**Subject:** 2025/91090 at location The Cask And Spindle, 112, Abbey Road, Shepley, Huddersfield, HD8 8EL

Please see ecological commentary below:

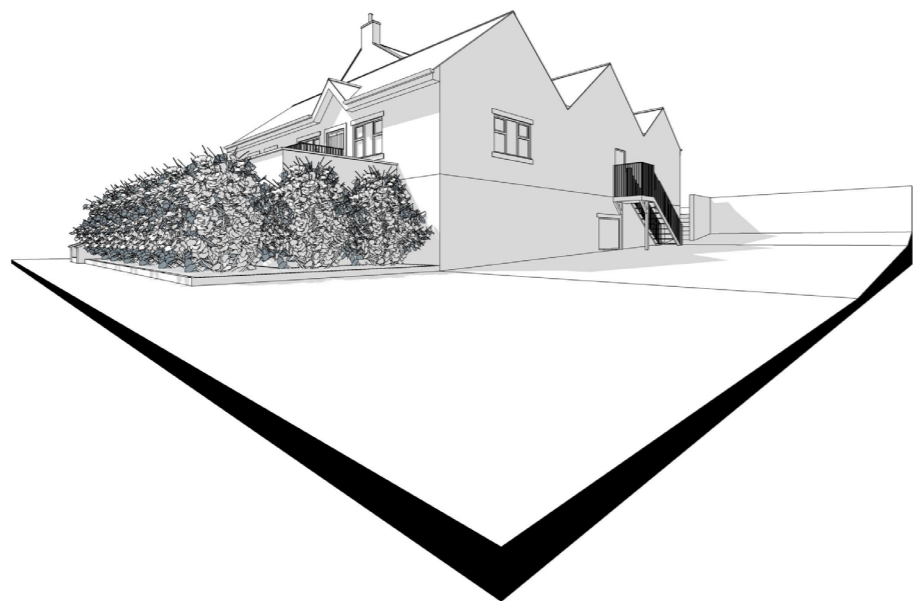
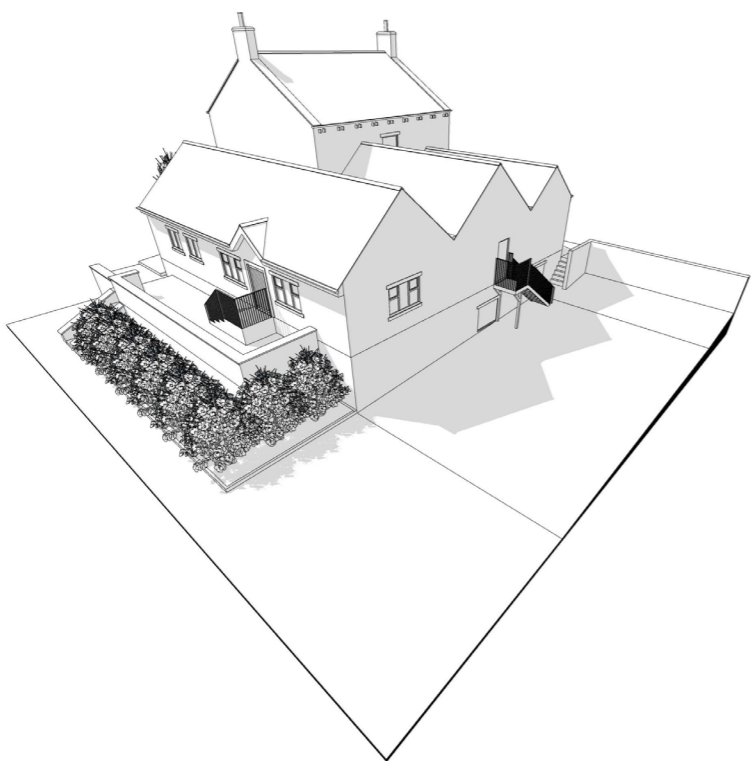
The build itself appears to have a number of potential features for bat roosting.

The extension appears to be intended to be developed on land that is originally hardstanding. As a result, Biodiversity Net Gain is exempt as set out in Schedule 7A of the Town and Country Planning Act 1990 (as amended). Should more information come to light, please do let me know.
